Arun District Council
Arun Civic Centre
Maltravers Road
Littlehampton
West Sussex BN17 5LF
Planning & Building Control General Enquiries
Tel: (01903) 737756 Fax: (01903) 730442
Dx: 57406 Littlehampton
Minicom: 01903 732765
e-mail: planning@arun.gov.uk
website: www.arun.gov.uk/planning

Application No: FG/46/21/PL
Site Address: Land between 11a The Grove and 30 Brook Lane Ferring
Description of works: Development of 1 no. 2 bed house set over 2 floors, with first floor being partially contained within roof, along with associated parking & amenity spaces. This site is within CIL Zone 4 and is CIL liable as new dwelling.

Thank you for your internet representation made on 29th April 2021 which has been recorded as an objection with the comments as follows:

Street Scene Visual

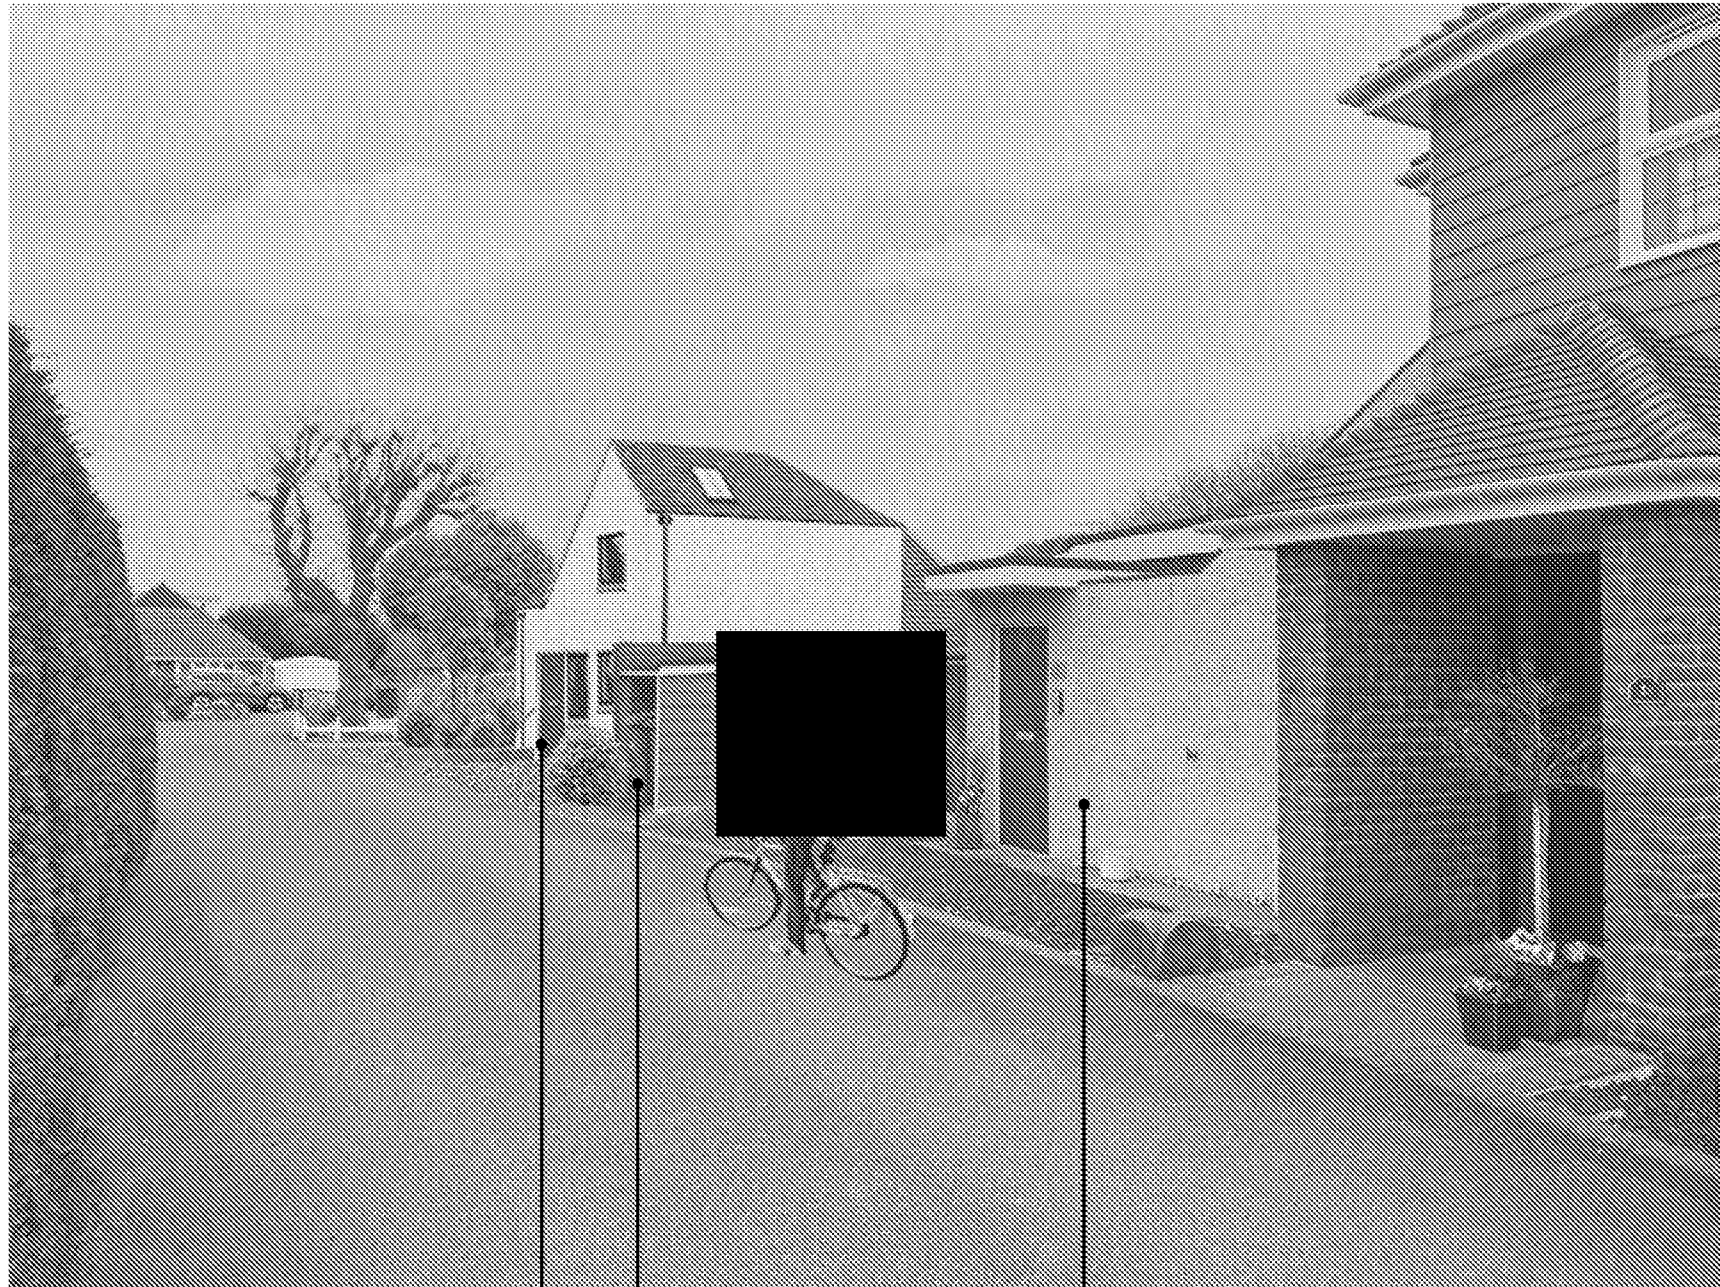
Overdevelopment of a garden plot causing it to be too close to neighbours on three sides, blocking daylight and having an overbearing presence due to height and proximity

Out of keeping with the rest of the bungalow properties in The Grove

Drawing Title 028_02 Proposed Ground Floor Plan Land between 11A The Grove and 30 Brook Lane, Ferring					
Completion date 17/03/2021					
Drawn by Guy Rochez ARB					
Scale: 1:100@A3					
Print Size: A3					
Notes:

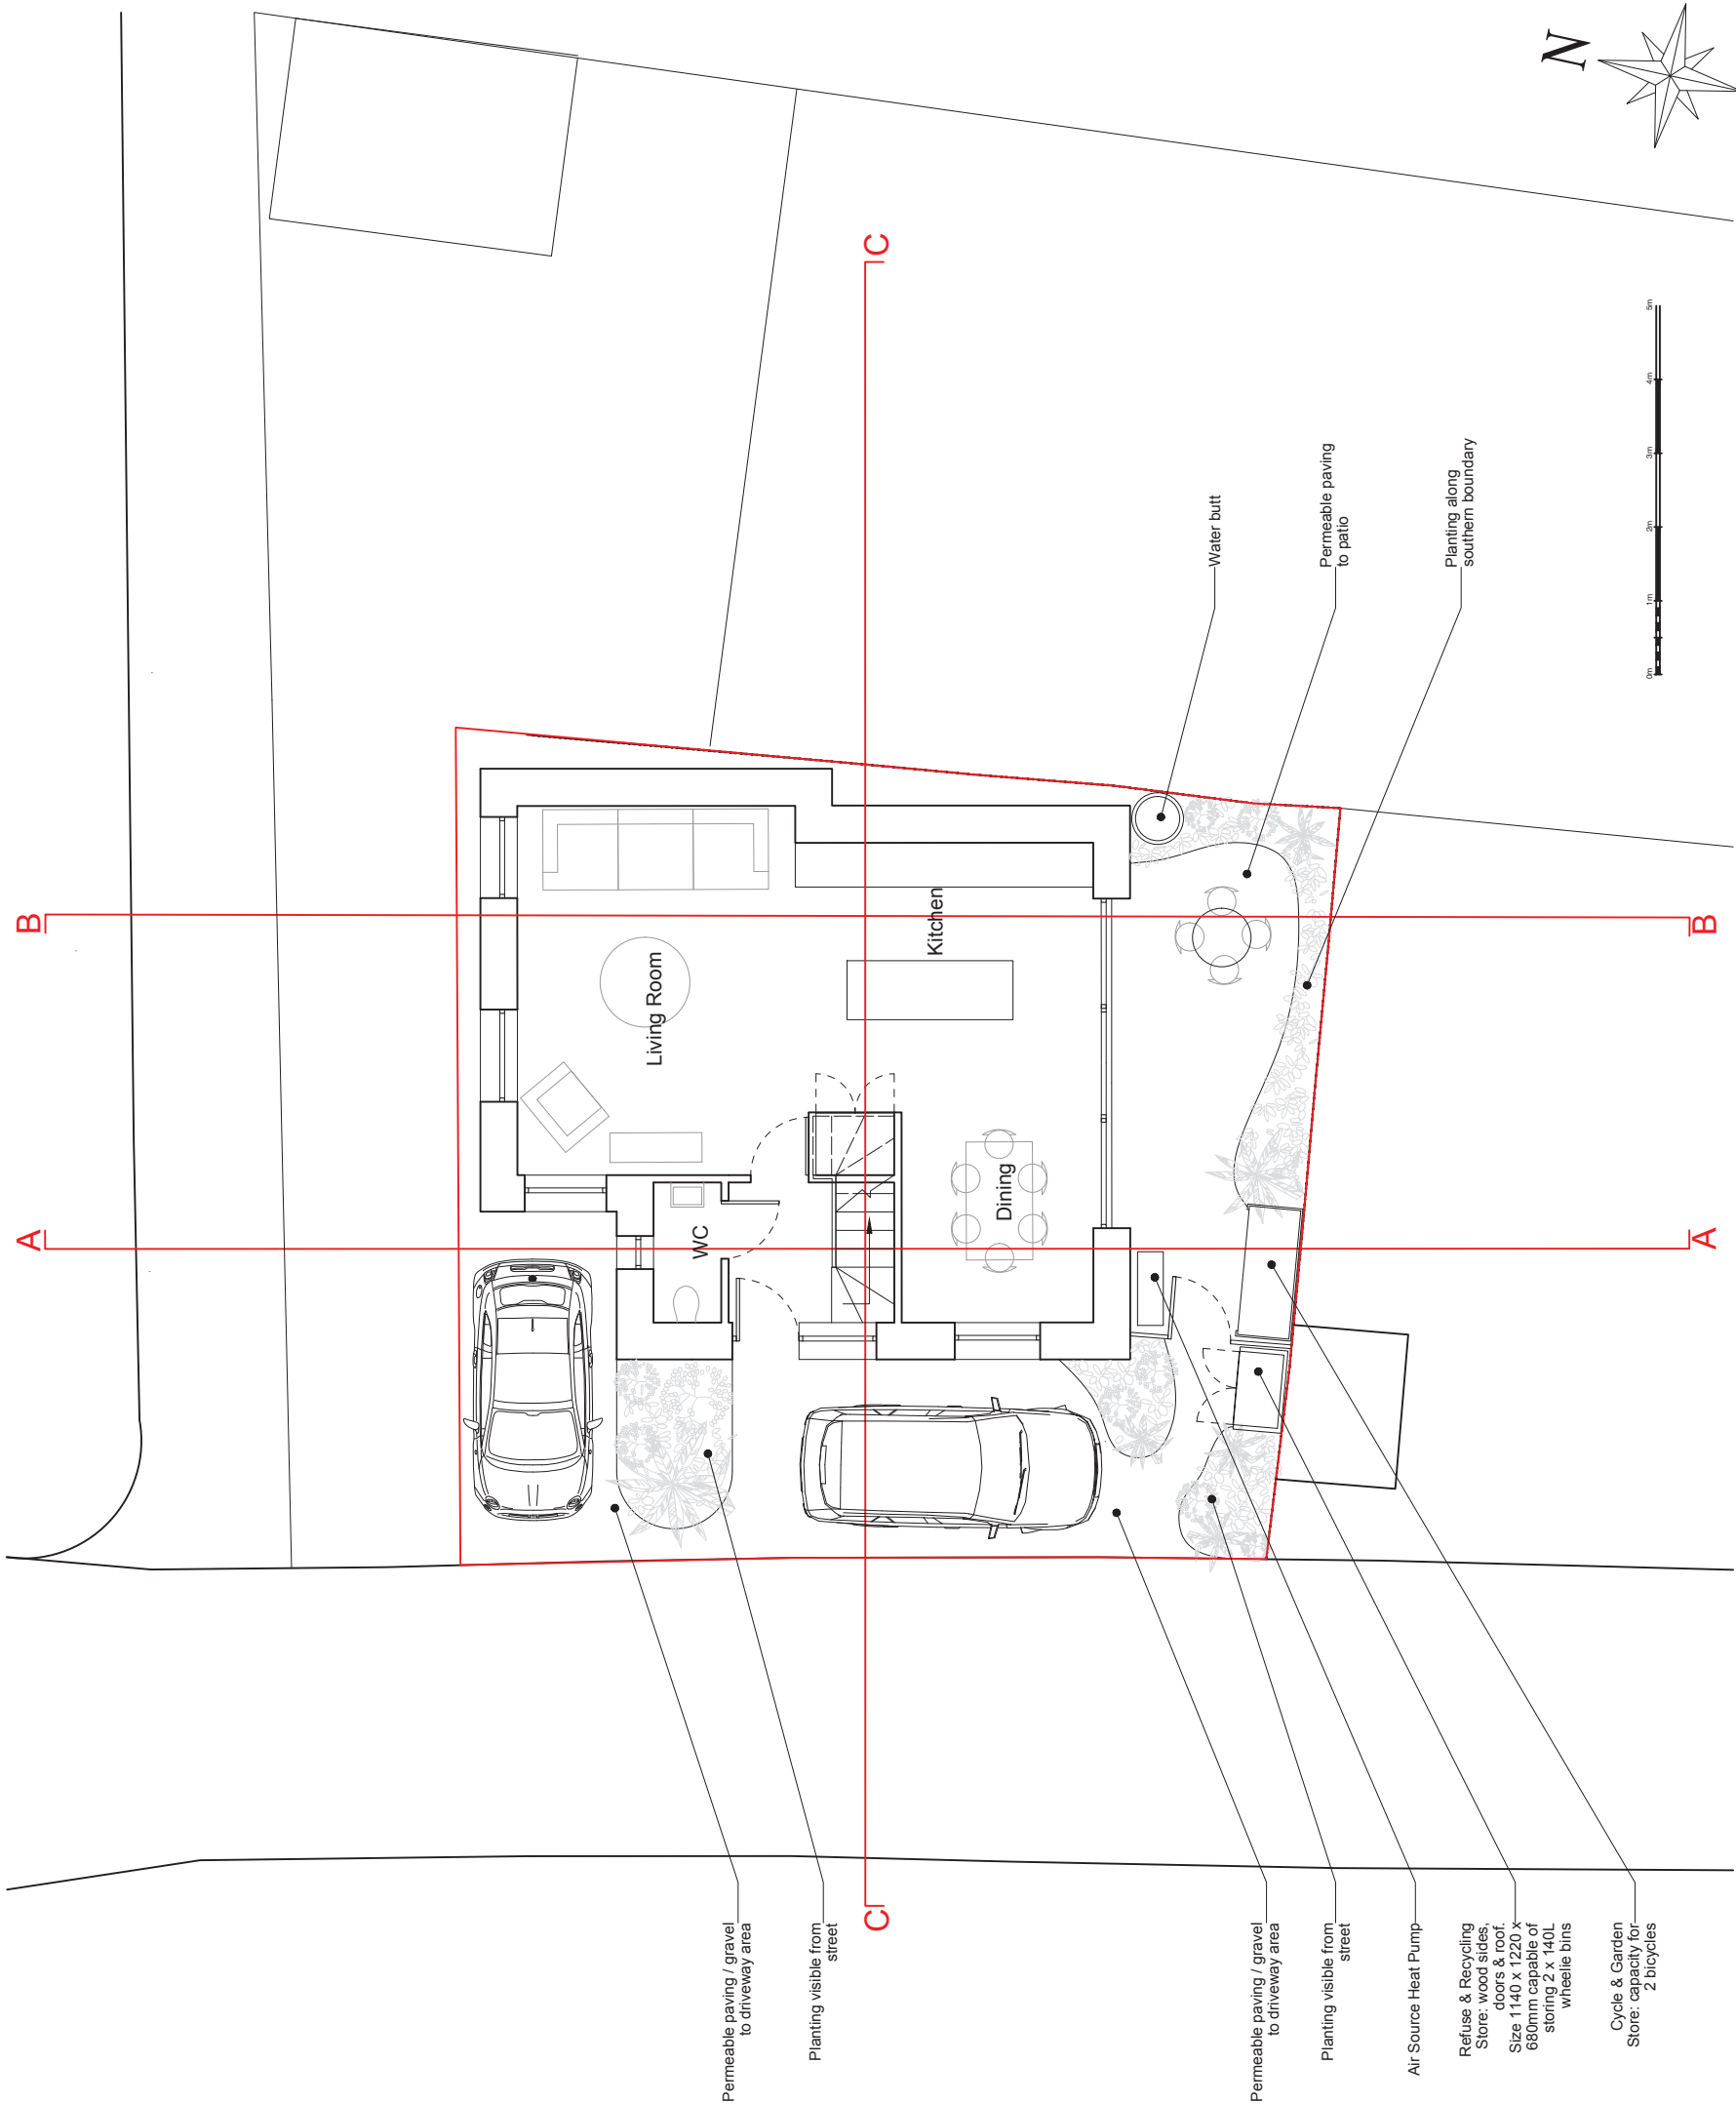
Visibility splay investigation is required for rear parking exit/entrance from 24 Brook Lane with The Grove. Proposed parking space obstructs line of sight

Not enough parking space on the proposal. The Proposed Ground Floor Plan, which shows parking spaces, is larger than the plot available. Parking already a problem locally with no on-street parking in The Grove.

Does not meet Arun Council's Design Guide for minimum depth of outside space

Drawing Title
028_03 Proposed First Floor
Plan
Land between 11A The Grove
and 30 Brook Lane, Ferring

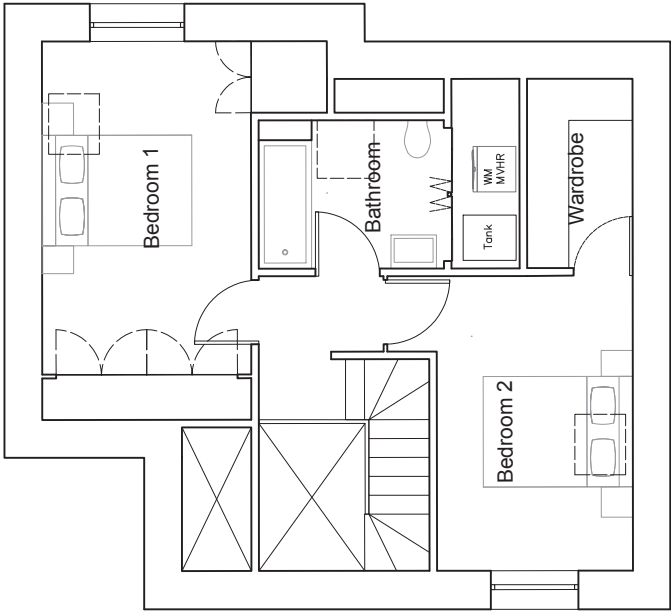
Does not meet Arun Council's Design Guide for minimum space between windows to habitable rooms

Loss of privacy to neighbours on three sides where windows overlook properties at close quarters
